West Midlands
Interchange

The West Midlands Rail Freight Interchange Order 201X
Applicant's Draft Response to ExA DCO and DCOB Comments (Agenda to ISH1)

ISH1 Agenda Annex 2 - Draft DCO – Structure, Definitions and Articles 1-49 (Agenda item 4)

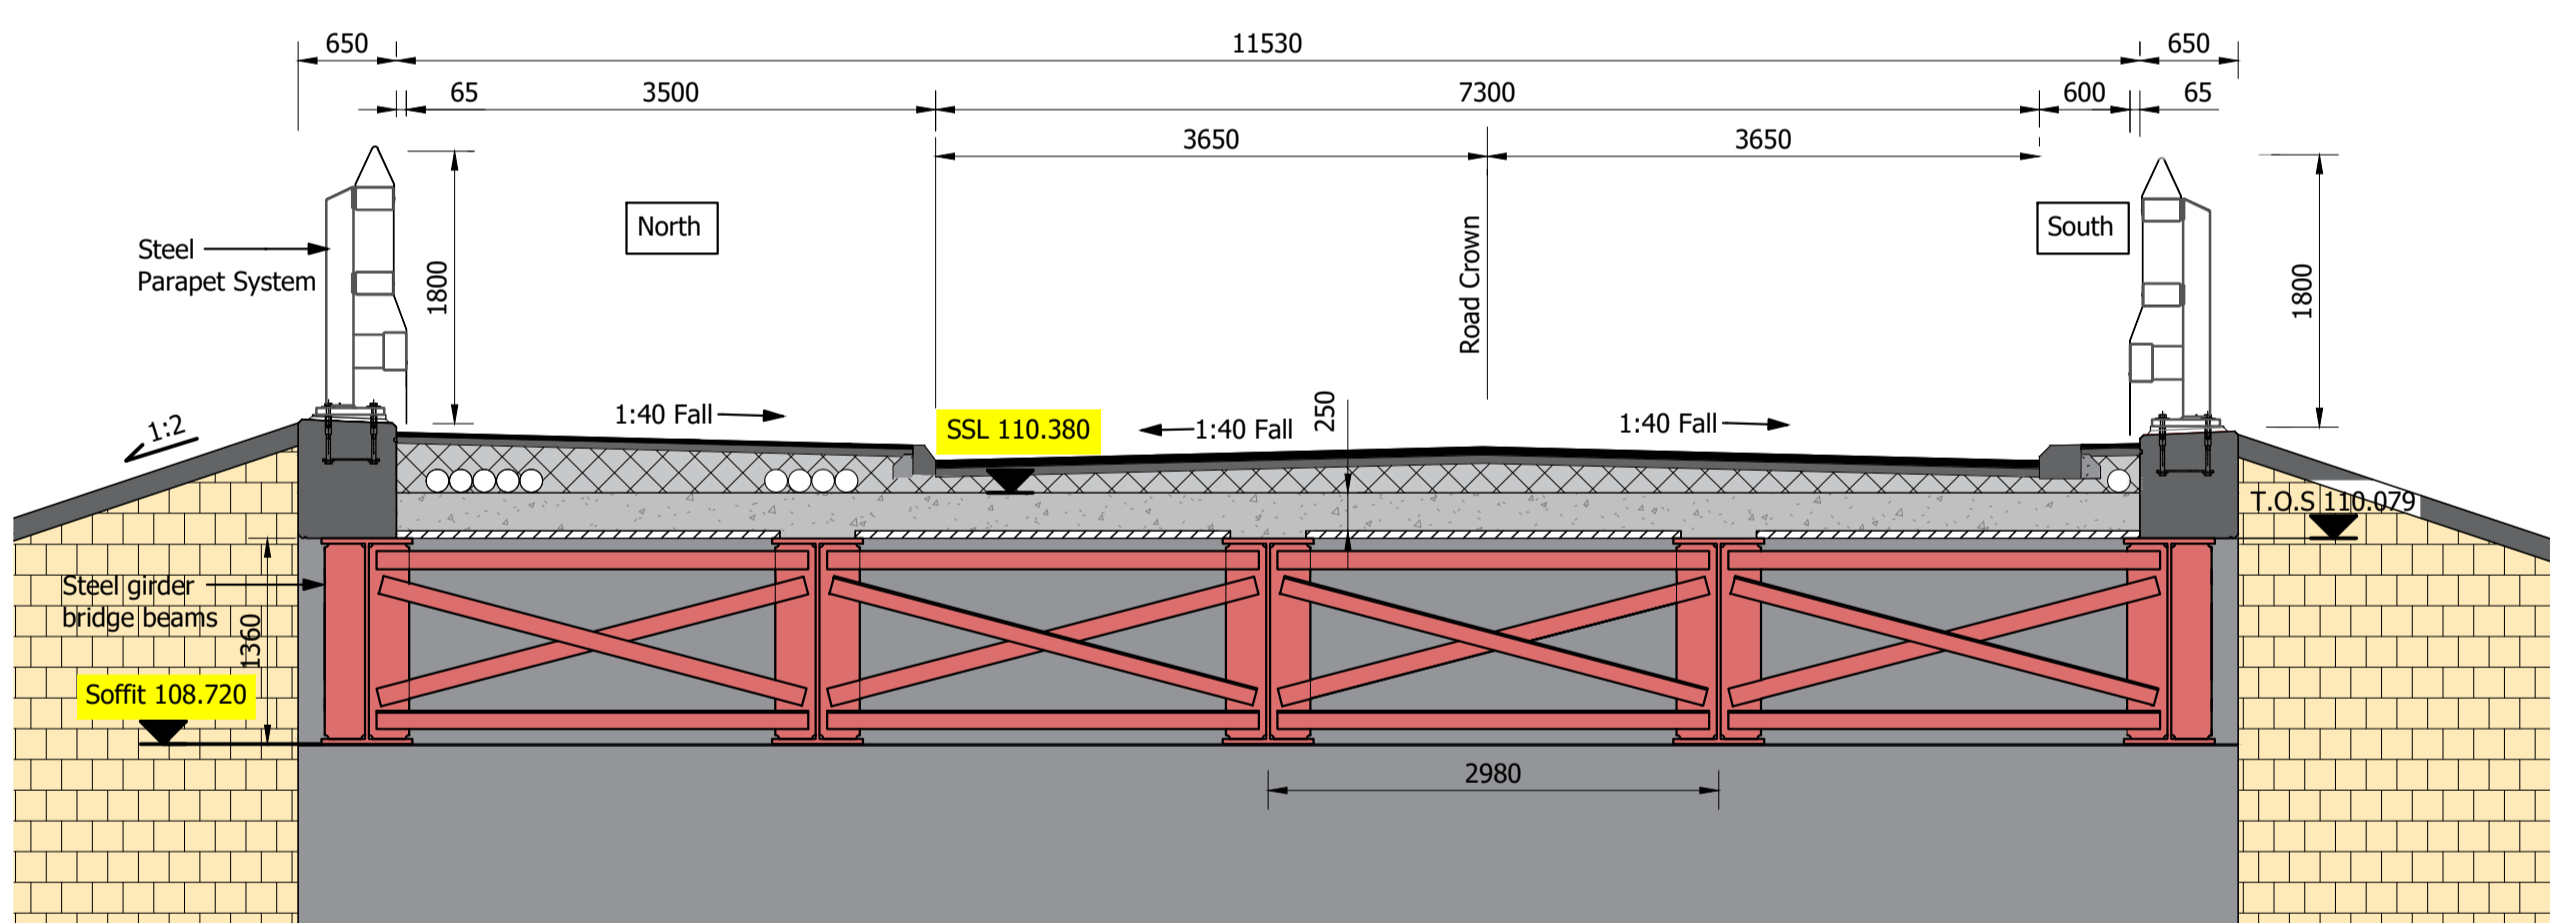
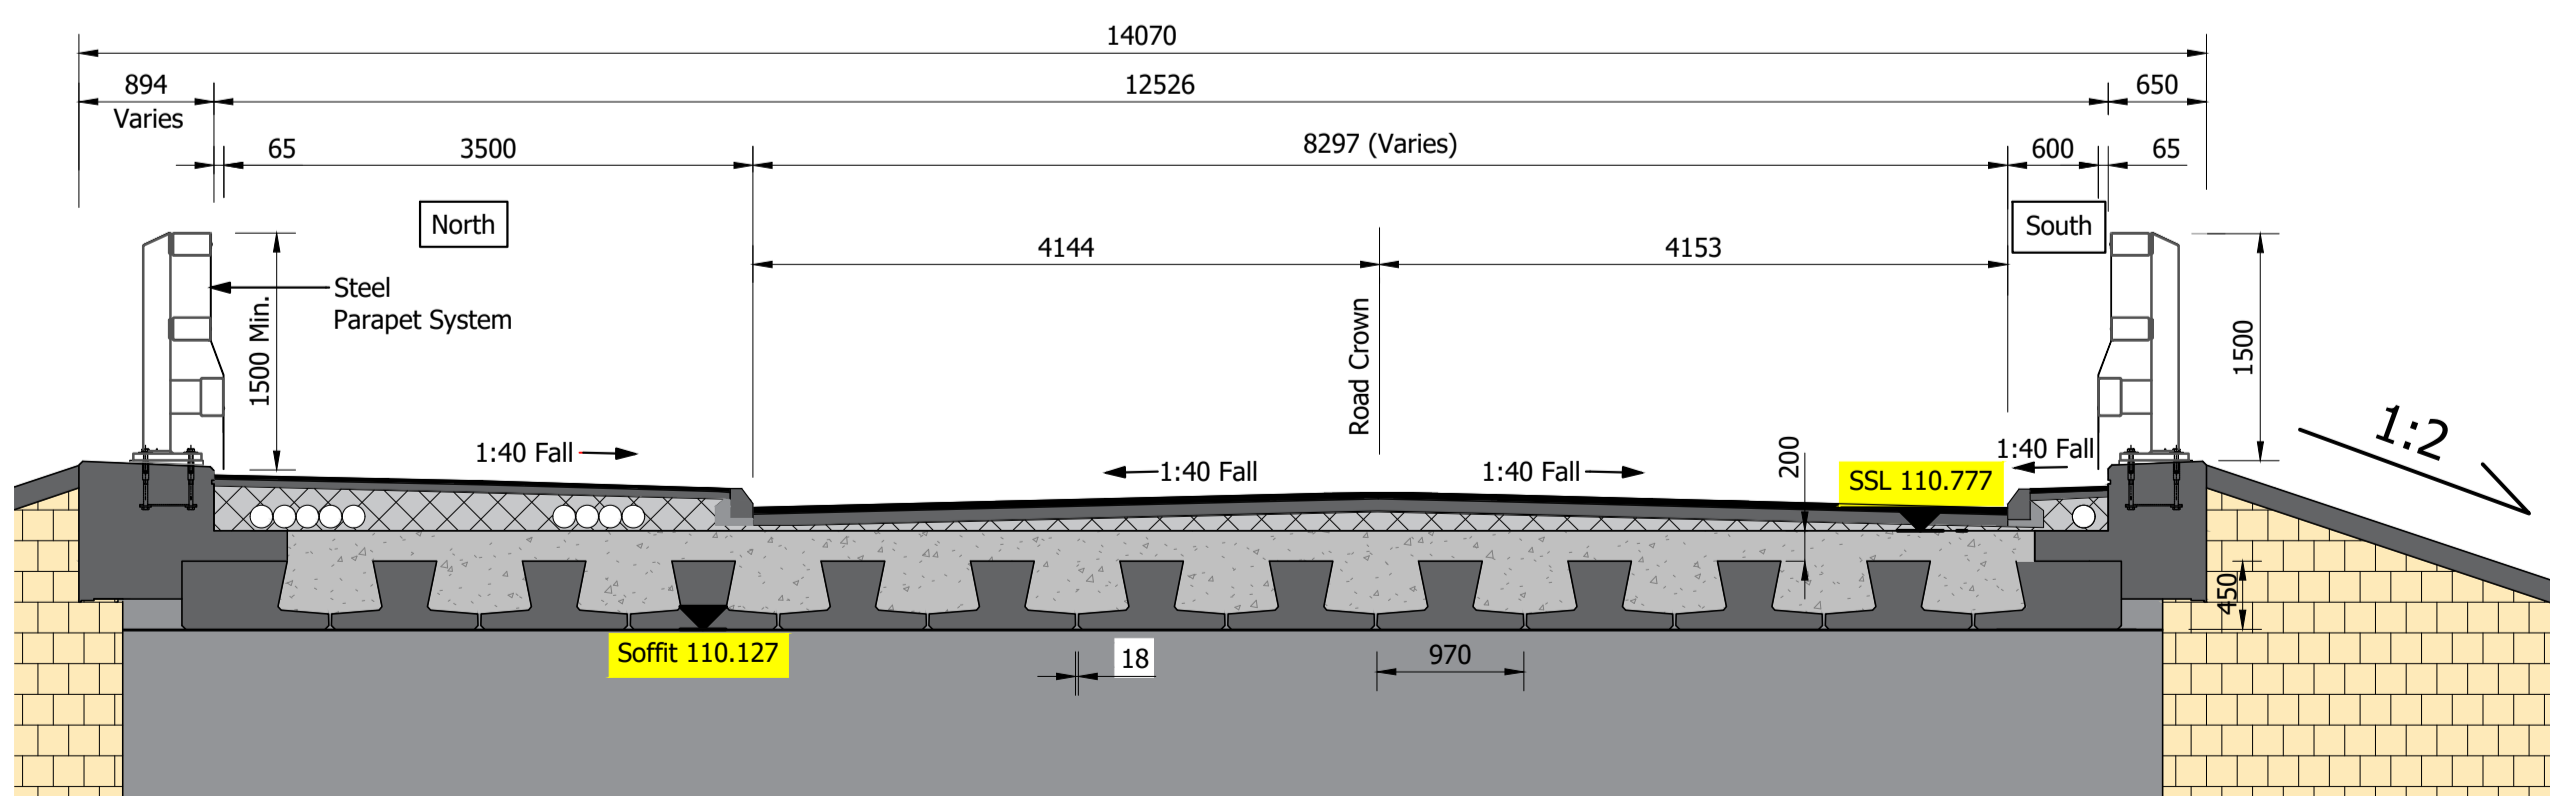
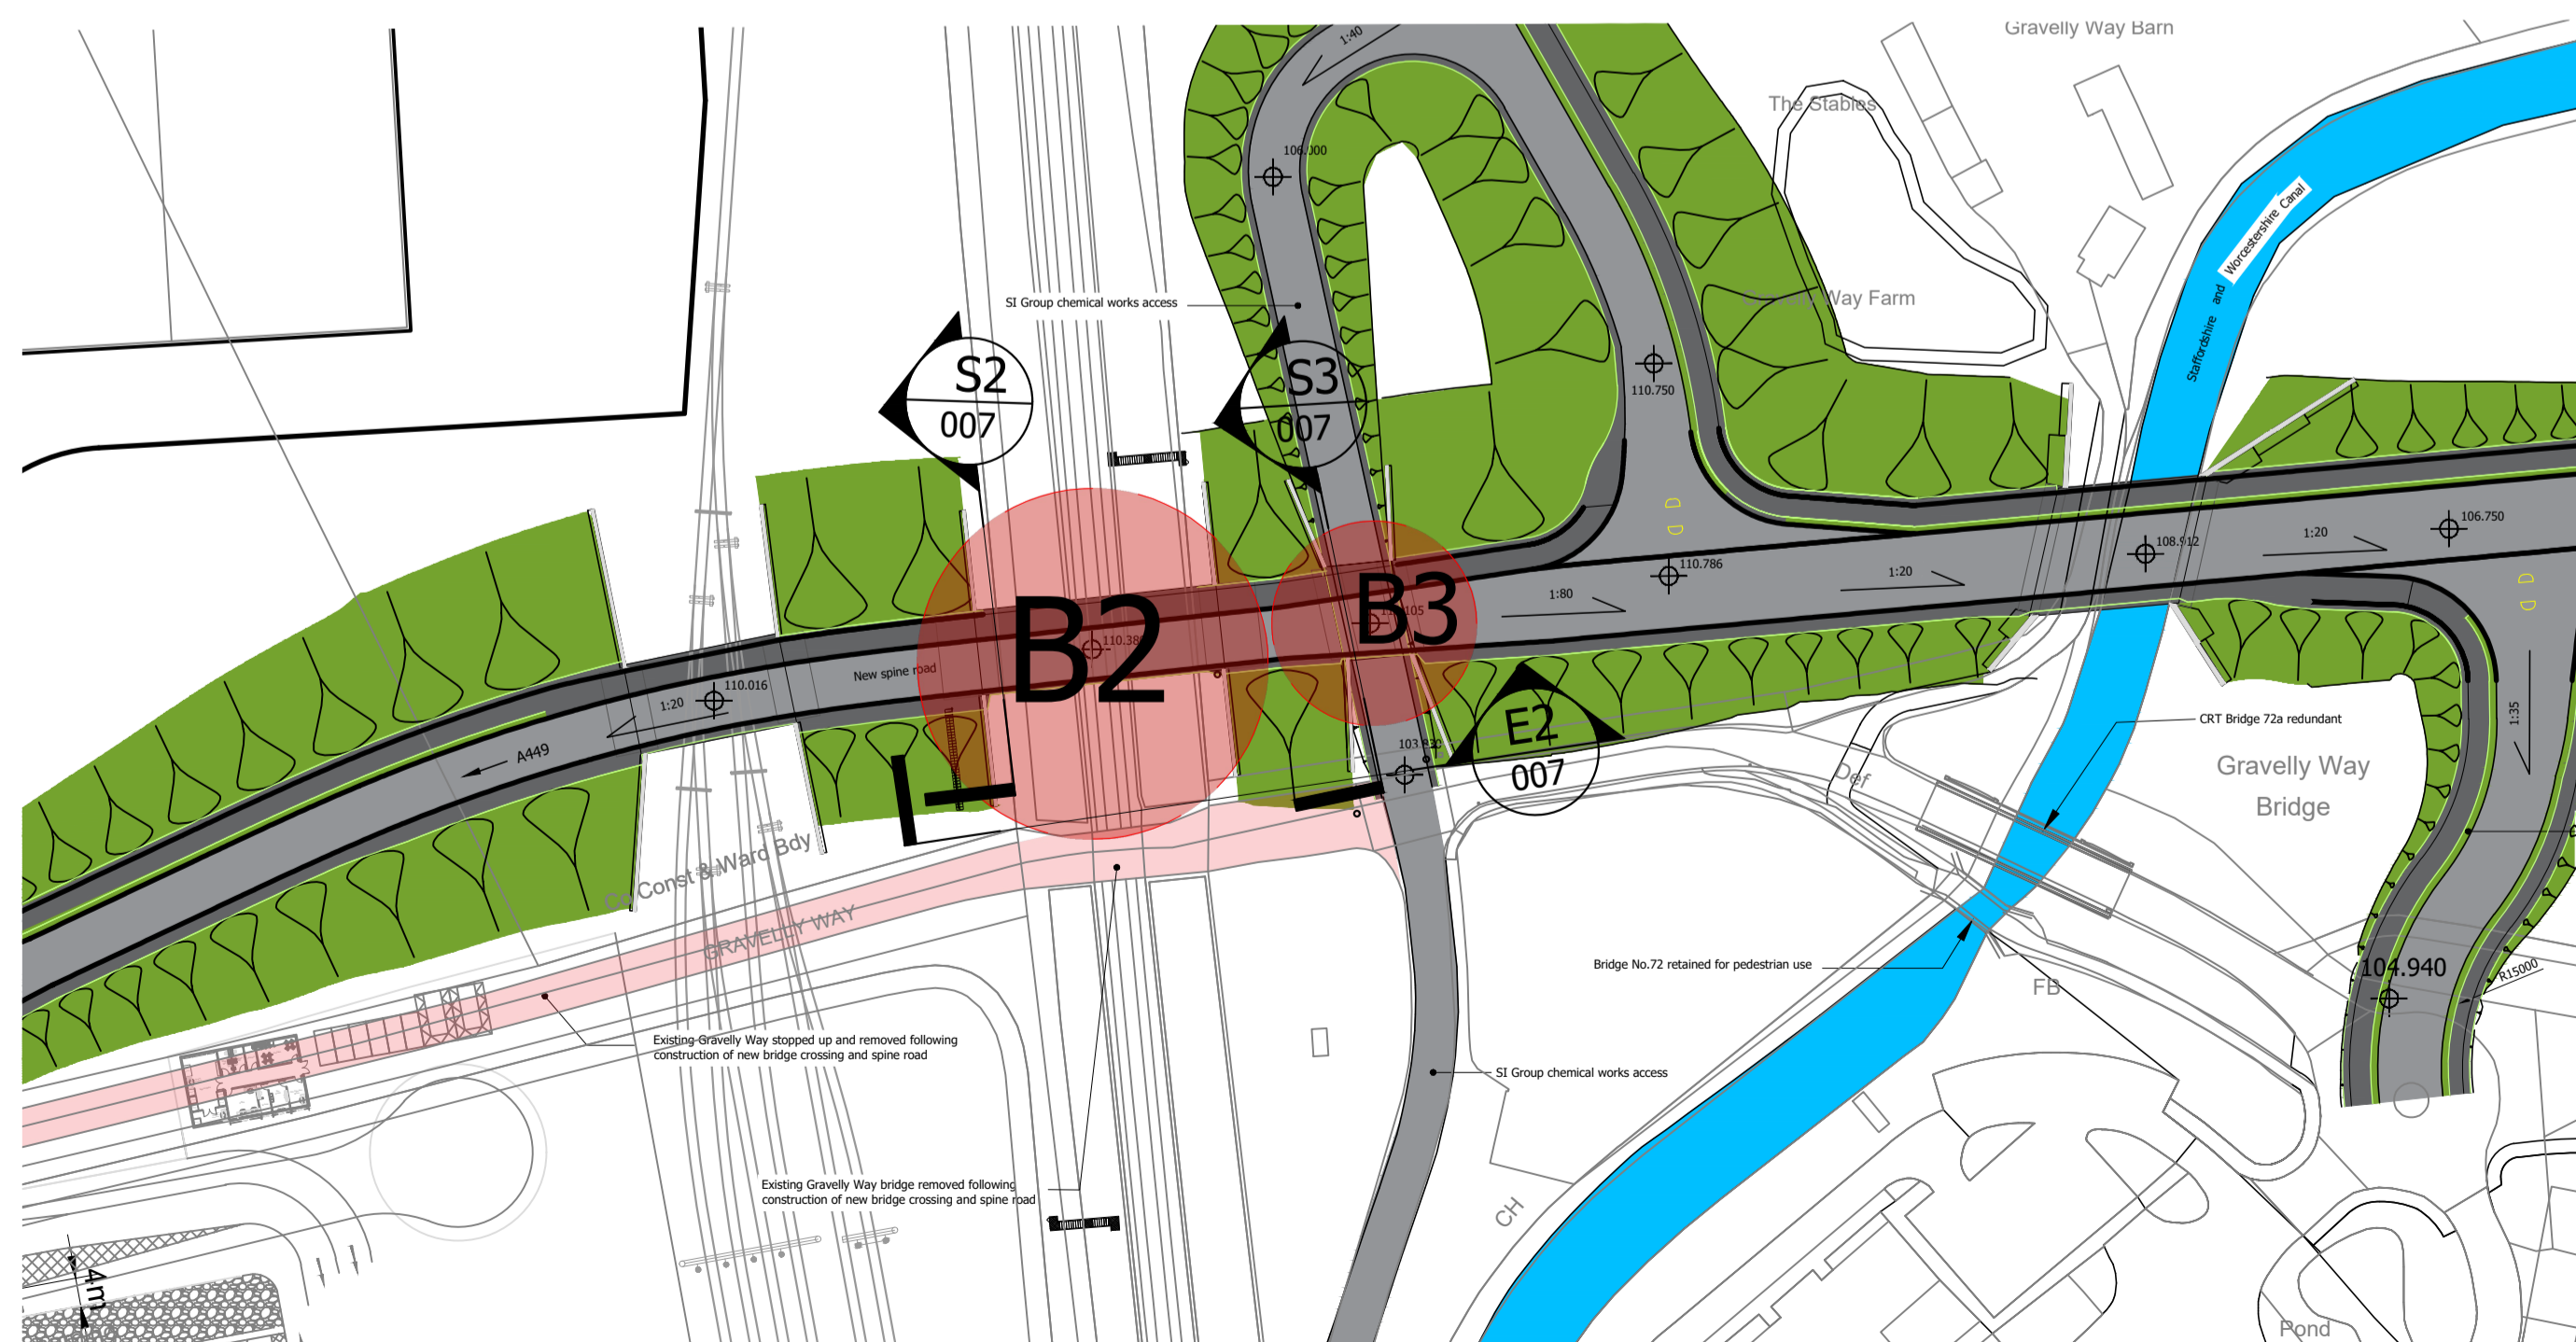
Q Ref	Part of DCO	Directed to	Question/ comment	Applicant's Response
1.10	A4	Applicant	<p>i) How would Clause (b) operate alongside the annotations on the Bridge Plans which indicate detailed levels for the underside, deck and other key elements of the proposed bridges and set minimum clearance levels for the underside of bridges?</p> <p>ii) Would there be a risk that the flexibility provided by Clause (b) might operate in tandem with that provided by Clause (c) (i.e. in relation to a bridge over part of the railway works) to result in an upwards deviation in the level of such a bridge by 3 metres?</p> <p>iii) Has the full degree of flexibility provided for in A4 been assessed in the ES on a worst case basis?</p>	<p>i) It is intended that the exact detail of the bridge design is to be approved before construction (requirement 3 will be amended to provide for that explicitly). The ExA will note that some of these annotations on the Bridge Plans refer to approximate distances. The maximum limits of deviation are required to ensure that the DCO allows for tolerance to accommodate normal variations required when construction details are known.</p> <p>ii) The Applicant does not consider that there is a risk of this, but will consider whether the wording of sub-paragraphs (b) and (c) might be suitably amended to alleviate any concerns. The railway works mentioned in sub-paragraph (c) specifically relate to Works 1 and 2, whereas the construction of the bridges is contained in Works 4. However, the Applicant understands the potential for confusion and suggests that article 4(b) is amended to refer to "bridges" rather than "bridge works", since the term "bridges" is defined with reference to the Bridge Plans.</p> <p>iii) The parameter plans make reference to the works plans and these, along with the stated variations in Article 4, have been considered in the ES where effects have been considered on a worst case basis.</p>
